**Office of
Environment
& Heritage**

RE: Bulli Seam Operations Modification 2 (PA 08_150 MOD 2)

Thank you for consulting us with regard to the abovementioned major project modification, known as the "Mine Safety Gas Management Project", which comprises installation of a 1 metre diameter gas pipeline of approximately 4km in length between Appin No. 3 Vent Shaft and Appin No. 2 Shaft, located predominantly within the Brooks Point Road reserve. We have reviewed the relevant information and have provided detailed comments at Attachment A and our key issues are discussed below.

ATTACHMENT A: OEH DETAILED COMMENTS ON BULLI SEAM OPERATIONS PROJECT MOD 2 (PA08_150)

Figure 3: Proposed gas drainage pipeline alignment

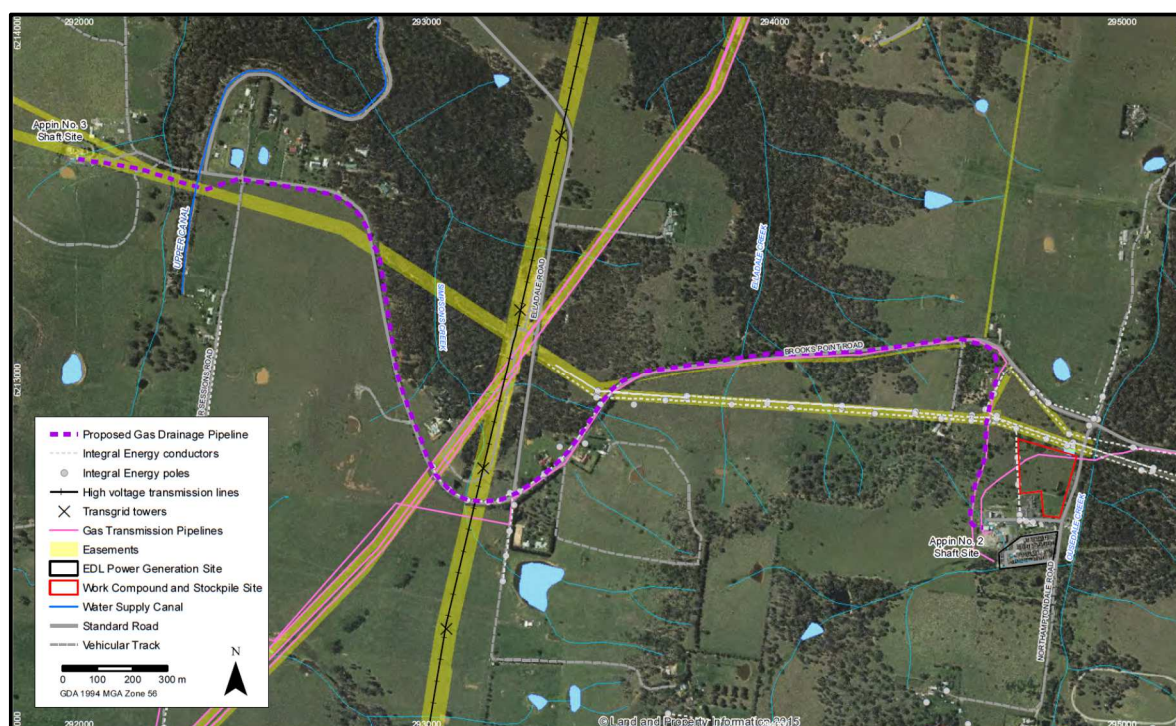
The currently proposed modification comprises a gas pipeline that largely traverses the alignment of Brooks Point Road, impacting approximately 0.45ha of regenerating Cumberland Plain Woodland within the project footprint. Cumberland Plain Woodland (CPW) is listed as a Critically Endangered Ecological Community (CEEC) under both the NSW Threatened Species Conservation Act 1995 and Commonwealth Environment Protection & Biodiversity Conservation Act 1999.

We recognise that the proposed alignment has been designed to avoid impacts on native vegetation where possible. The assessment concludes that the proposed modification is unlikely to result in a significant impact upon threatened species, populations or ecological communities and their habitats, including CPW CEEC. Notwithstanding this conclusion, we recommend that a suitable like-for-like biodiversity offset be provided for the 0.45 hectares of CPW CEEC to be cleared, consistent with the intent of the Offset Policy for Major Projects. The proponent should provide details of this offset in accordance with an appropriate methodology prior to approval of the modification, in order to demonstrate that a 'maintain or improve' outcome in accordance with the Director-General's Requirements can be met.

However, there are less disturbed portions of the easement at the south eastern and western ends of the easement that run through cleared paddocks. In these sections, the disturbance to the land has been much lower. Archaeological sites, in particular stone artefact scatters, are routinely found within cleared paddocks in this region. While no landscape features have been identified as being likely to contain archaeological deposit, the low ground surface visibility through these sections and the low levels of prior disturbance mean that there is an increased potential for Aboriginal objects to be impacted by the pipeline in these areas.

If there are any changes to the alignment of the construction easement, or the impact area of the construction works including any stockpiling and laydown areas, the proponent must ensure that the alignment has been assessed for the potential to impact Aboriginal objects. This is especially relevant given the recorded sites in close proximity to the easement.
